ENGLISH HERITAGE  
NORTH WEST REGION

Our ref: L00115400

**Notifications under Circular 01/2001, Circular 08/2009 & GDPO 1995**  
**TALBOT HOTEL, 5 TALBOT STREET, CHIPPING, PRESTON, LANCASHIRE, PR3**  
**2QE**  
**Application No 3/2011/0821**

Proposed Second Floor Site Plan

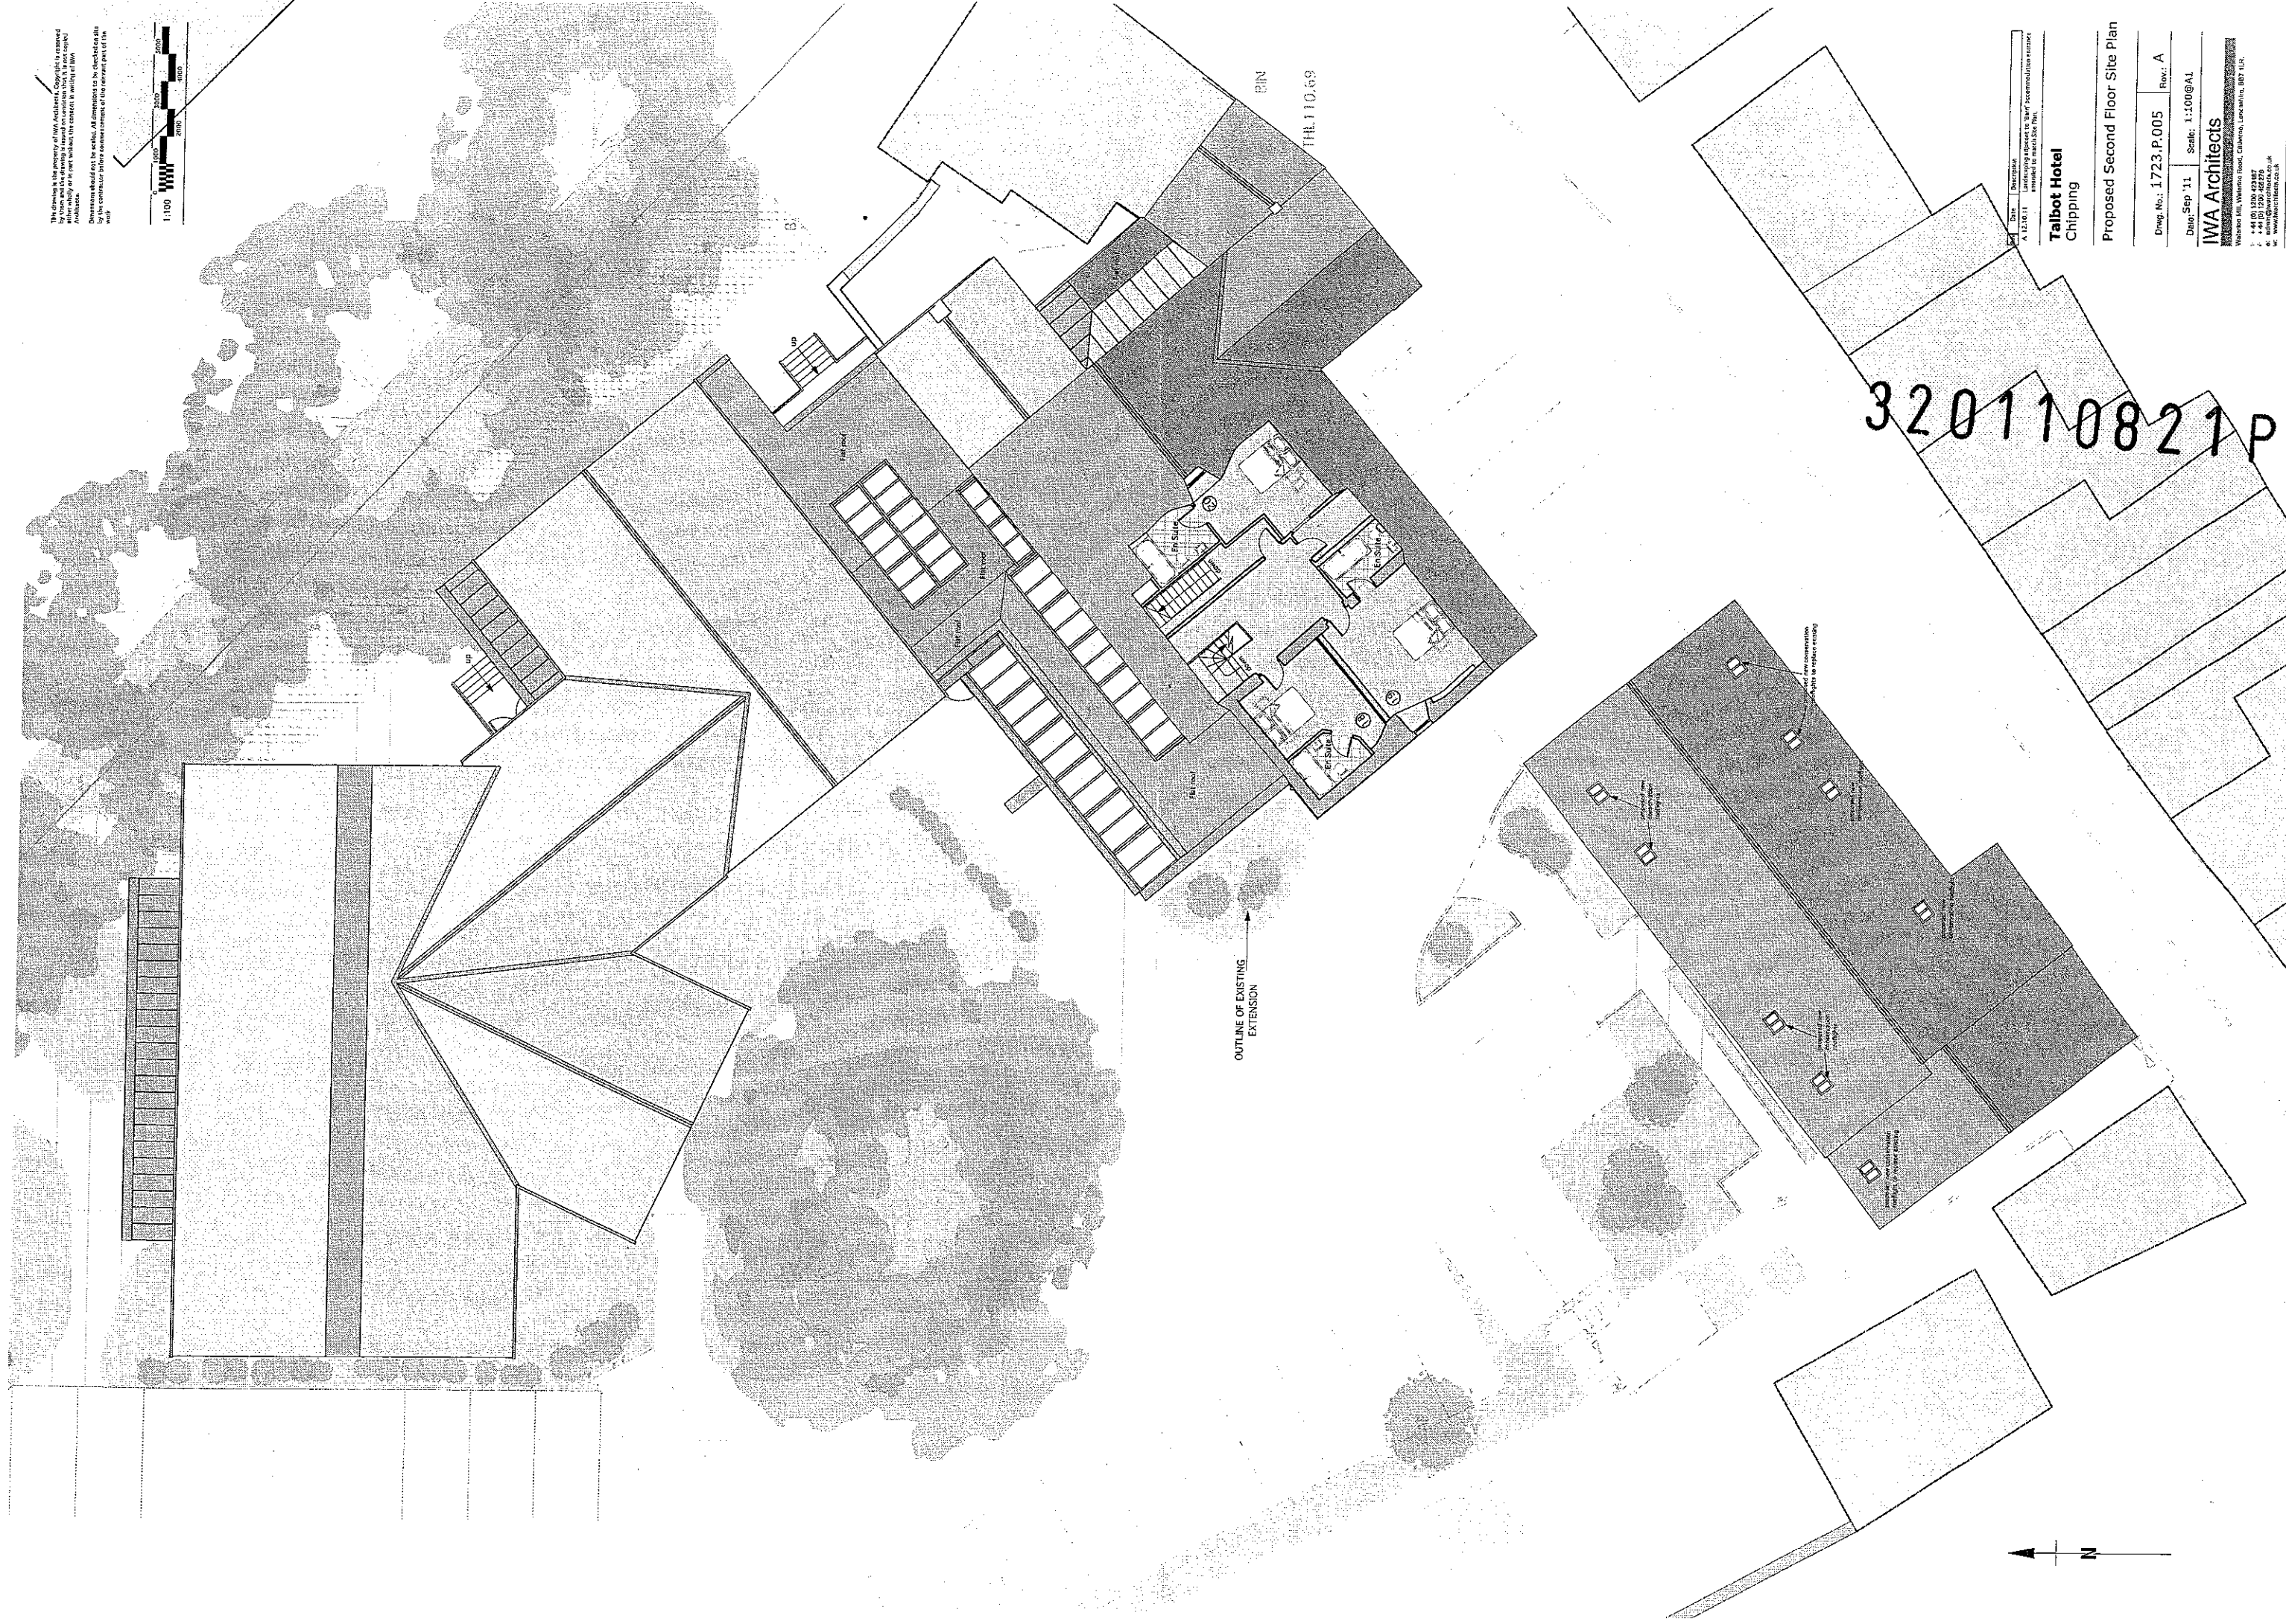
The proposed new opening through principal internal wall on the second floor, into bedroom 19, would result in the loss of historic fabric and appears to lack justification and could be avoided through amending the proposed layout. We suggest that it may well be possible to make an ensuite in the within the room, similar to bedroom 18, or alternatively to have a separately accessible bathroom, or an ensuite, in order to avoid the impact on significant historic fabric. Similarly, on the first floor, reversing the ensuite arrangements for bedrooms 13 and 14 would result in less loss of historic fabric.

Hotel and Function Room
Proposed Elevations - Sheet 1

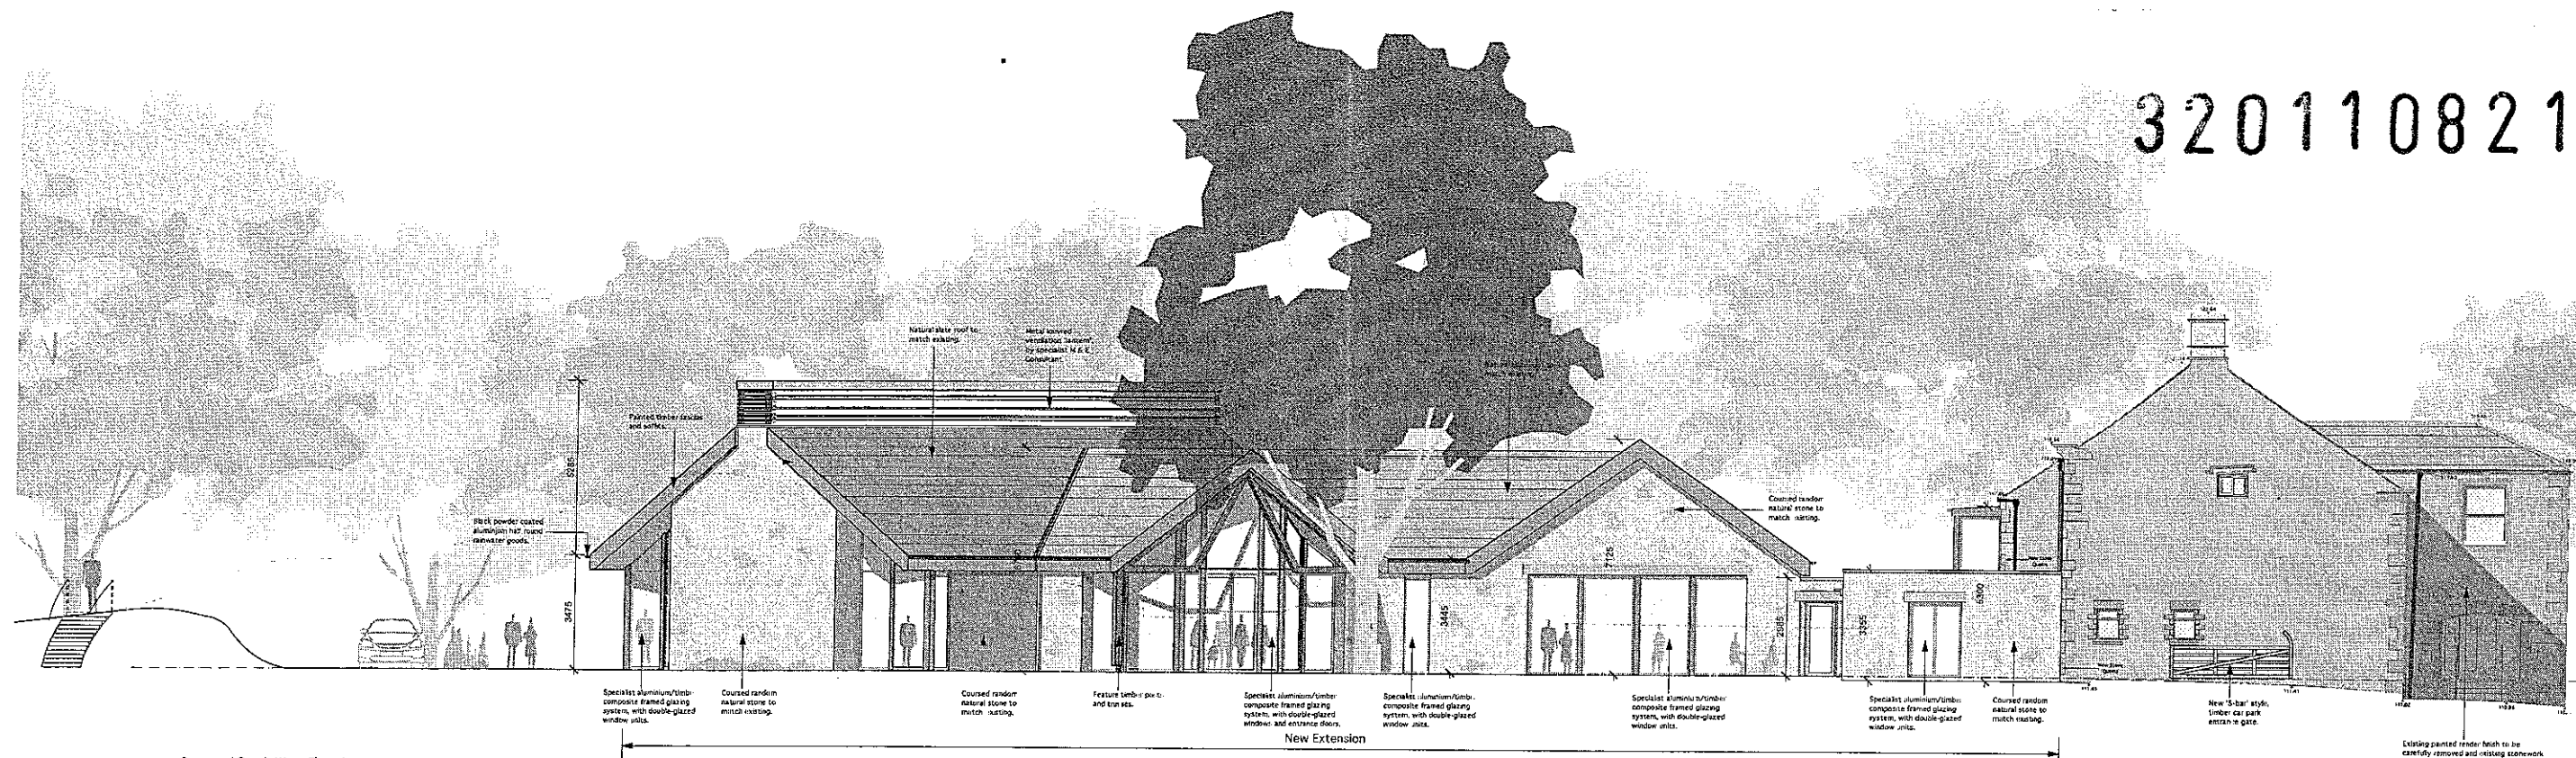
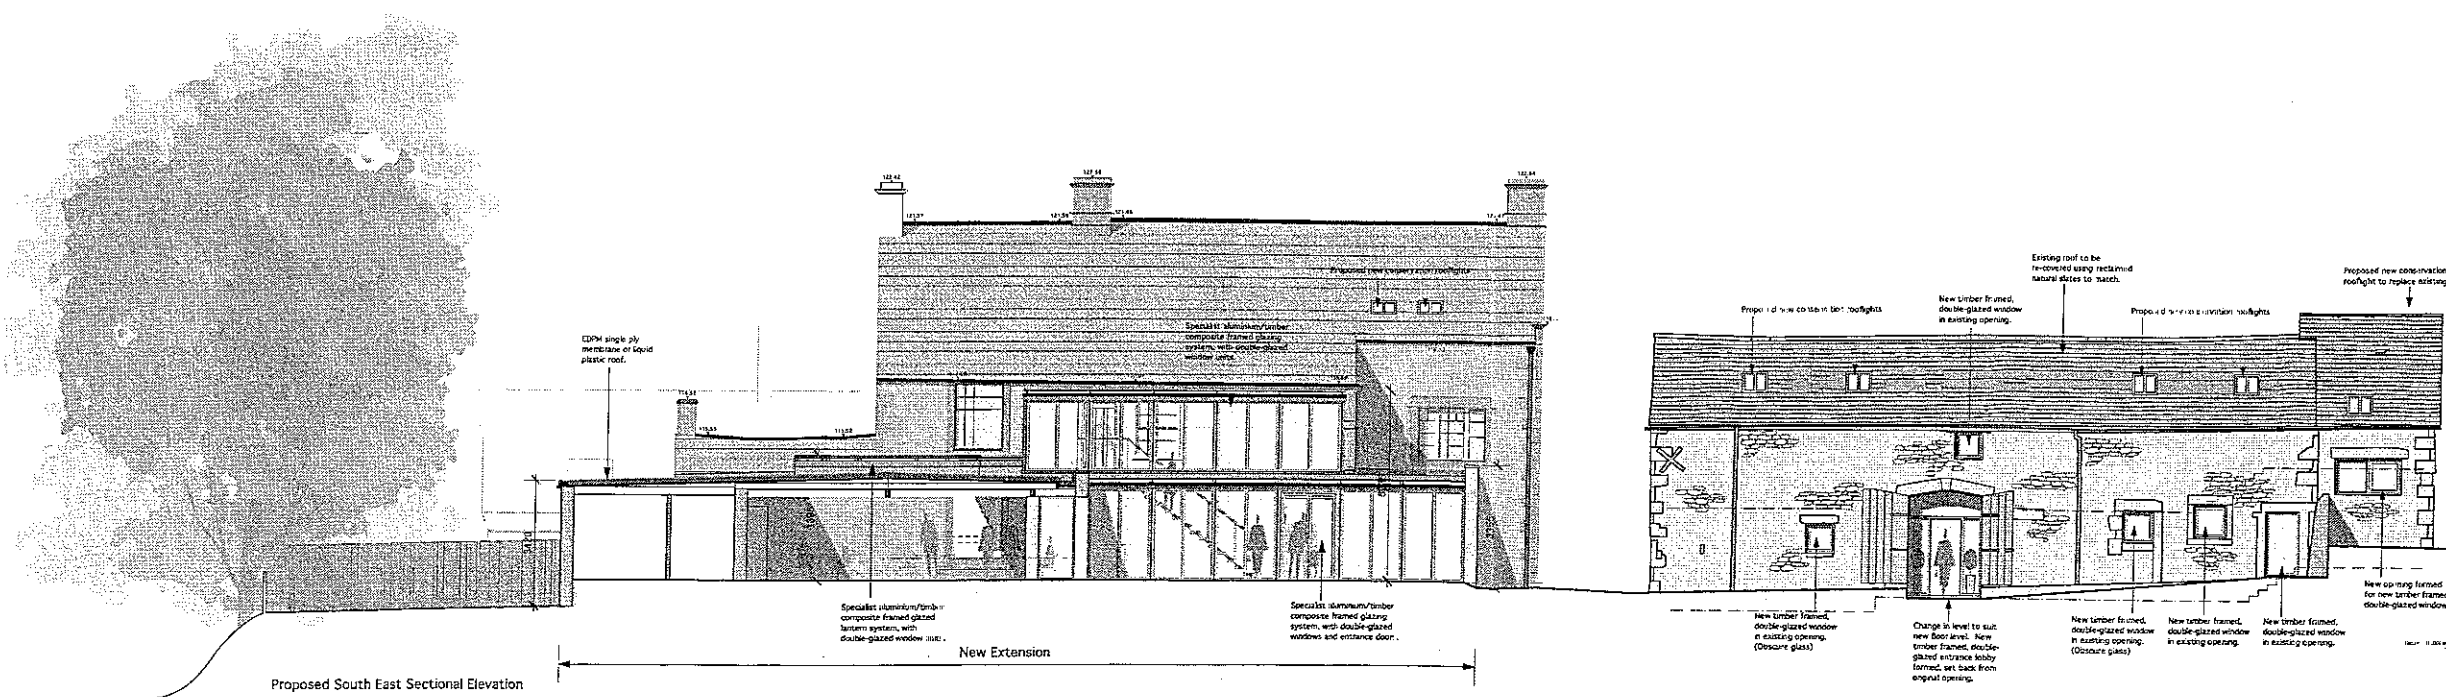
PPS5, policy HE7.5 requires local planning authorities when assessing proposals to take into account the desirability of new development making a positive contribution to the character and local distinctiveness of the historic environment. At present, the proposed extensions, by virtue of their scale, height, massing and roofscape, have an overbearing impact on the Grade II listed Hotel. The HEPPG, para 186 states that 'new features added to a building are less likely to have an impact on the significance if they follow the character of the building. The design of the various structures at the rear do not in our view respond to the character and appearance of the Grade II listed hotel or the Grade II listed barn.

Therefore, should your Authority be satisfied that the need for the amount of new development has been justified, we suggest that consideration should be given to the desirability of introducing a more subservient extension, or separate accommodation block to the rear of the Hotel or Stables and barn. This could be achieved through a simplified design of lower units, possibly with an agricultural outbuilding character, set in a linear arrangement or arranged in a courtyard plan which would be more sympathetic to the layout and setting of the hotel, result in a less harmful impact on the setting of both Grade II listed buildings, addressing PPS5, policy HE10.2.
